Our Ref: EP/141/19/NMA

**Section 96A of the Town & Country Planning Act 1990 (as amended)
Town and Country Planning (Development Management Procedure) (England) Order 2015 (as amended) - Article 10**

Non-material amendment following the grant of reference EP/129/18/HH to lower garage roof and amended material treatment on rear gable from brick to tile hanging.

42 The Roystons East Preston BN16 2TS

PROPOSED PLANS, ELEVATIONS AND ROOF PLAN  
**CONSTRUCTION ISSUE**

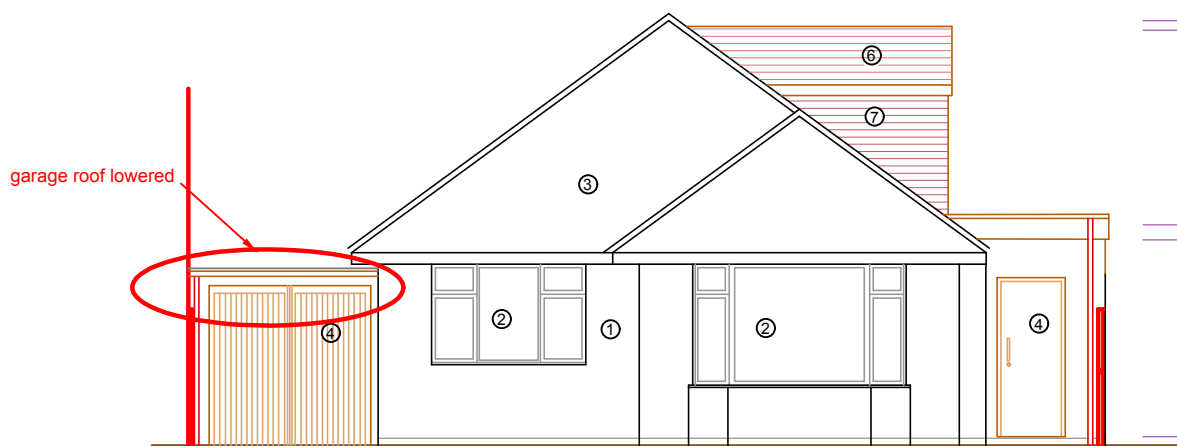
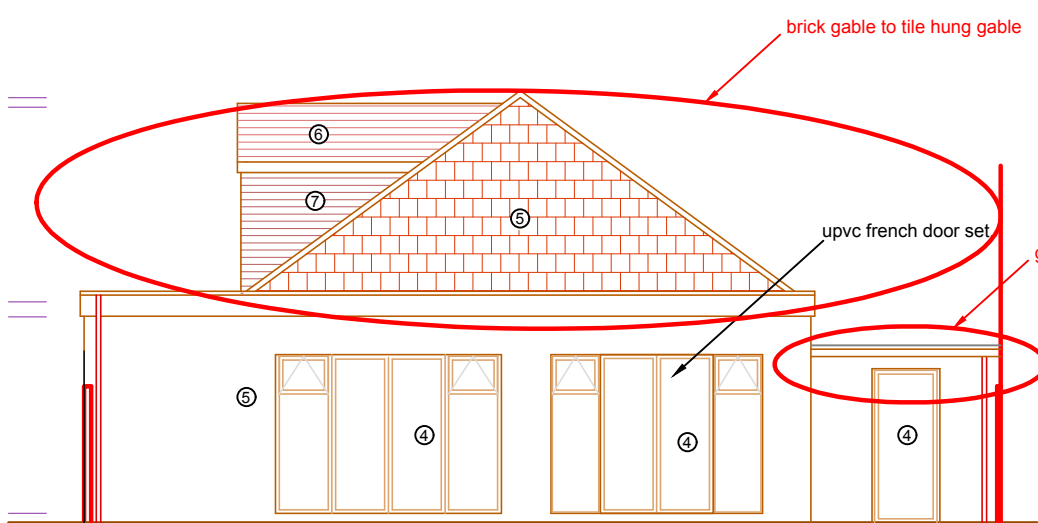
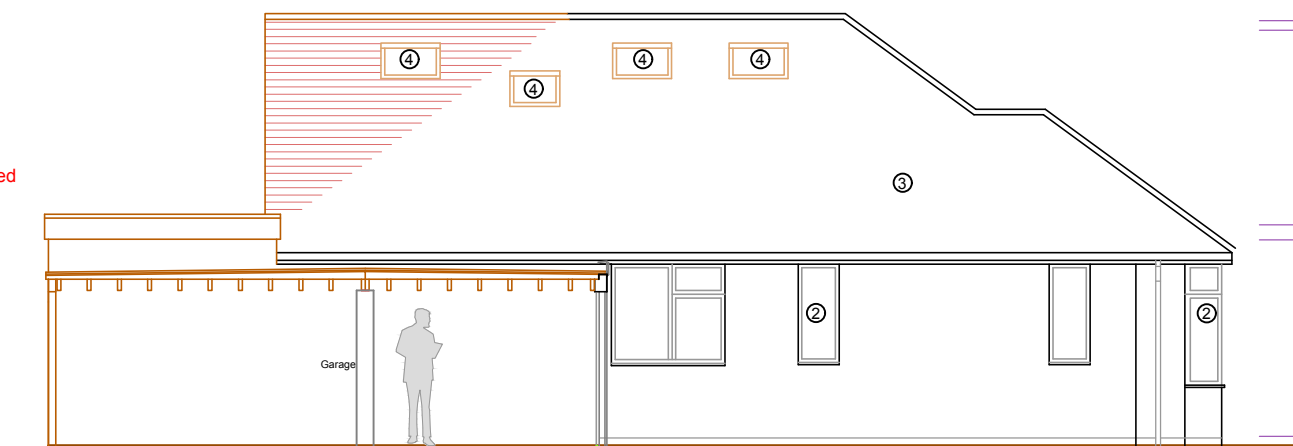
I refer to your recent application for a Non Material Minor Amendment. I note that you seek to lower the garage roof, and amend the rear facing gable material, from brick to hanging tiles.

Please note that drawing reference 'Proposed Floor Plans, Elevations, Block and Roof Plan - 18032/02R3 - 07/11/2018' is replaced by 'Proposed Plans, Elevations and Roof Plans - 183016/01G 0 30/10/2019'.
